**KIRKLEES METROPOLITAN COUNCIL
INVESTMENT & REGENERATION SERVICE**

**DELEGATED DECISION FOR APPLICATION FOR CERTIFICATE OF
LAWFUL DEVELOPMENT**

Reference no.: 2025/CL/92293/E

Site: 9, Rock Terrace, Quarry Lane, Woodkirk,
Dewsbury, WF12 7JF

SECTION THRO'

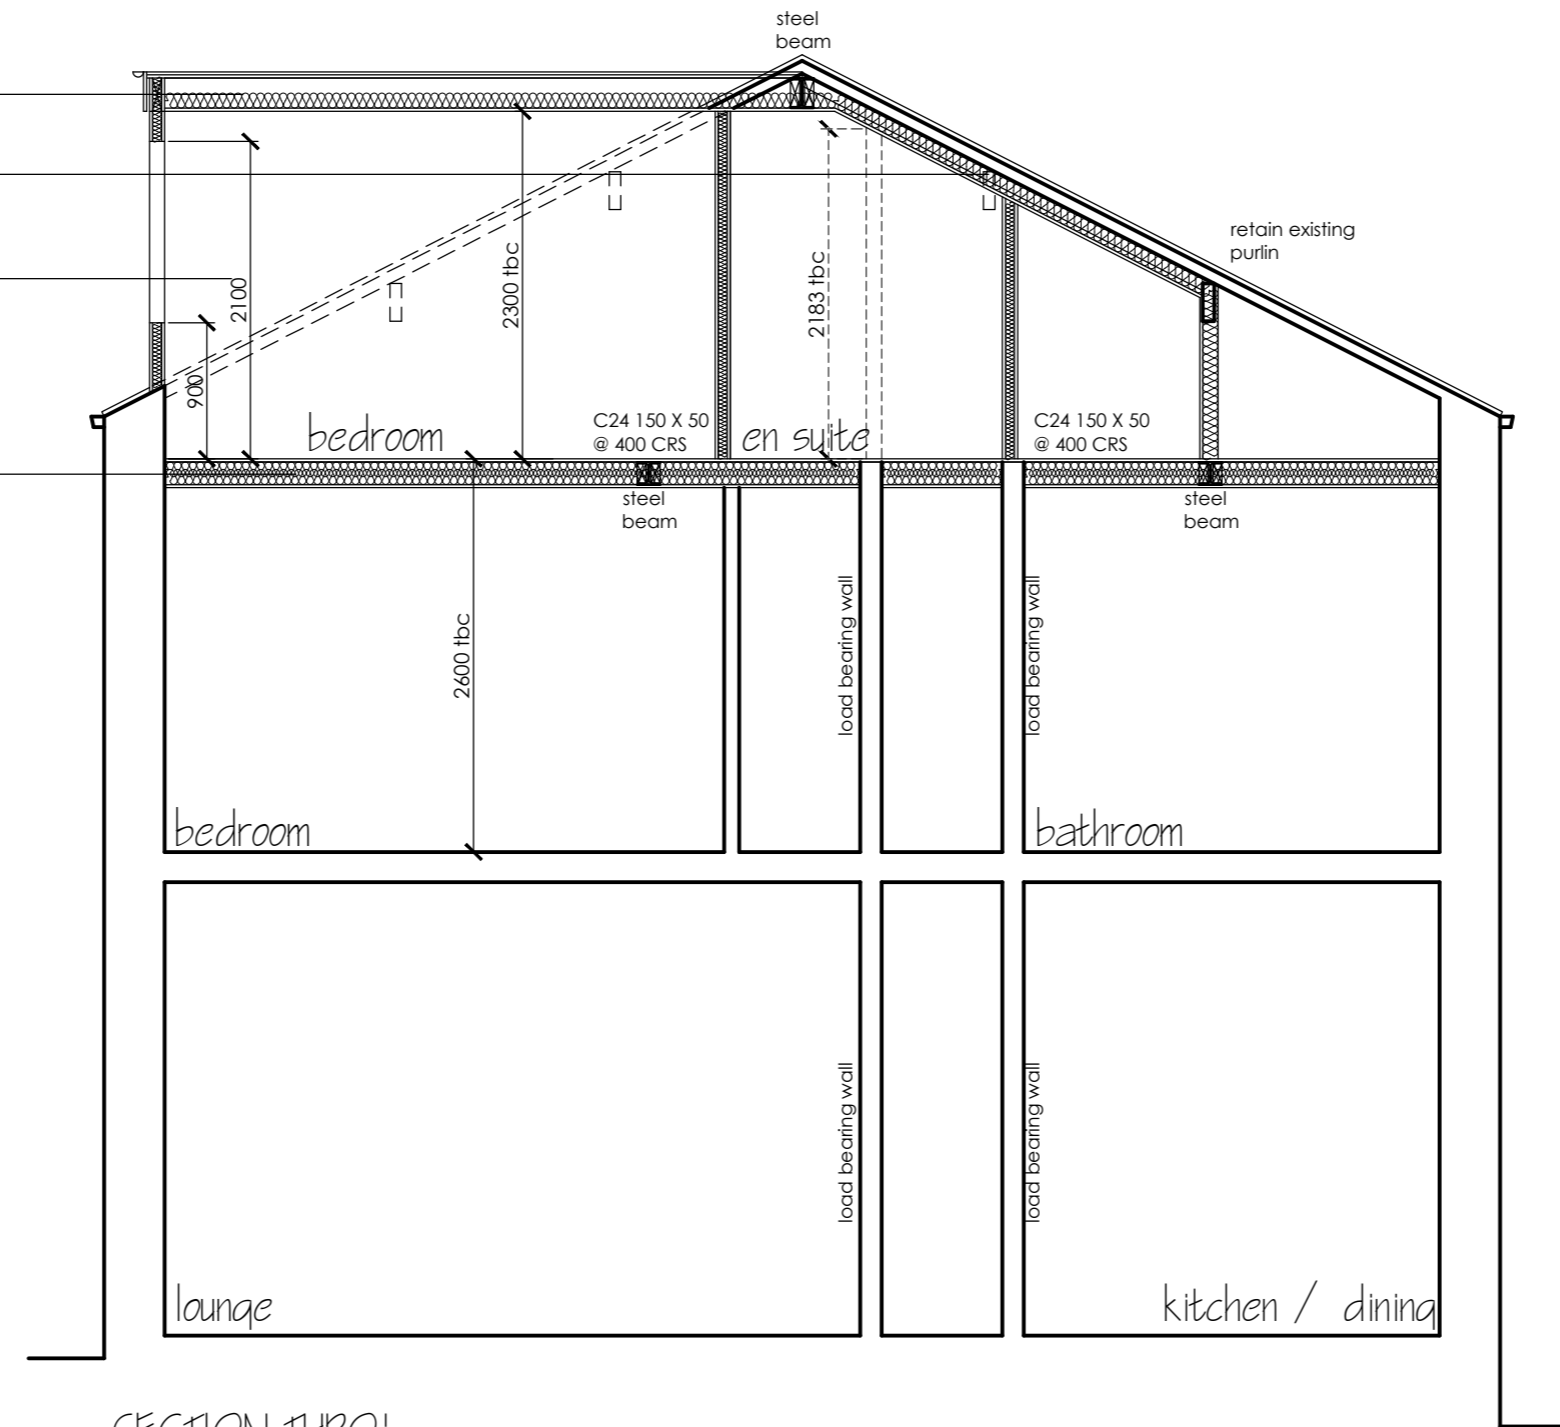
A dormer is proposed on the rear (south facing) roof slope, set back from the existing eaves by approximately 0.4 metres being a width of 4.58 metres. The dormer would project 4.1 metres from the roof ridge and would be a total height of 2.08 metres. The total cubic volume increase would be approximately 19.5 cm³.

Comment: *No part of the roof addition, as a result of the works, exceed the height of the highest part of the existing roof.*

Comment: *The cubic content of resulting roof space would not exceed 40 cubic metres.*

The proposed enlargement to the roof, roof light and porch have been assessed against the relevant legislation, Town and Country Planning (General Permitted Development) (England) Order 2015(as amended), Schedule 2 Part 1, Class B and C and it has been deemed that the dormer extension and roof light are permitted development. As a result, they do not require planning permission, and the lawful development certificate is therefore approved.
